SSD-76440958 South House - Mixed use development with infill affordable housing - Crown Street, Wollongong

I refer to the Department's email of 24 October 2025 regarding the Environmental Impact Statement (EIS) for State Significant Development SSD-76440958 South House - Mixed use development with infill affordable housing - Crown Street, Wollongong for 'Mixed use development with infill affordable housing comprising 4 residential towers, commercial and hotel buildings including retail premises with associated carparking, landscaping and public domain works' at 221 - 291 Crown Street, 216 - 238 Keira Street and 86 - 90 Burelli Street, Wollongong (Various lots) in the Wollongong City Council local government area (LGA). Submissions need to be made to the Department by 6 November 2025.

Figure A 3-3 Mezzanine Level Plan

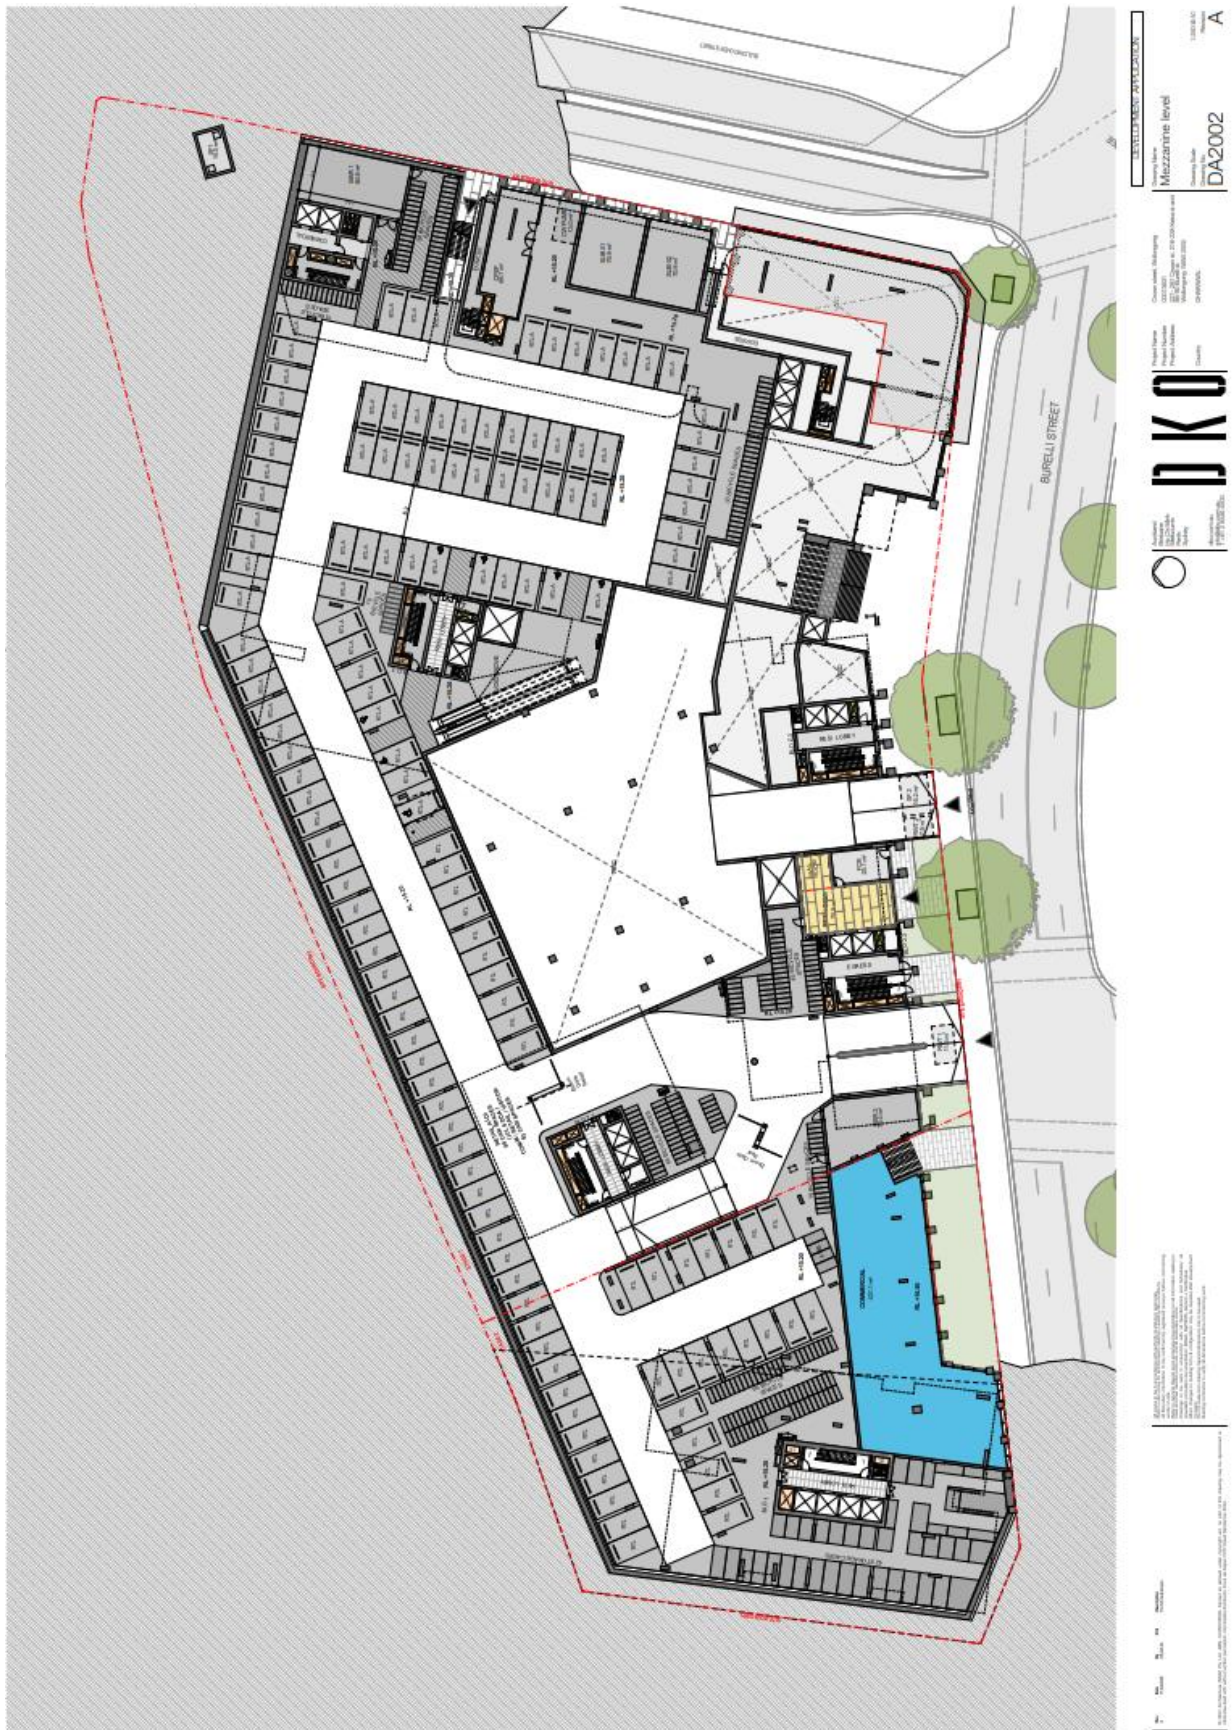
The below copy of the Mezzanine Plan shows provision for two indoor substation chambers to the Keira Street road frontage of the site.

Any required distribution substation/s will need to be located within the property (in a suitable and accessible location) and be protected (including any associated cabling not located within a public road / reserve) with an appropriate form of property tenure as detailed in the attached copy of Endeavour Energy's 'Land Interest Guidelines for Network Connection'.

Generally it is the Level 3 Accredited Service Provider's (ASP) responsibility (engaged by the developer) to make sure substation location and design complies with Endeavour Energy's standards the suitability of access, safety clearances, fire ratings, flooding etc. If the substation does not comply with Endeavour Energy's standards, the applicant must request a dispensation.
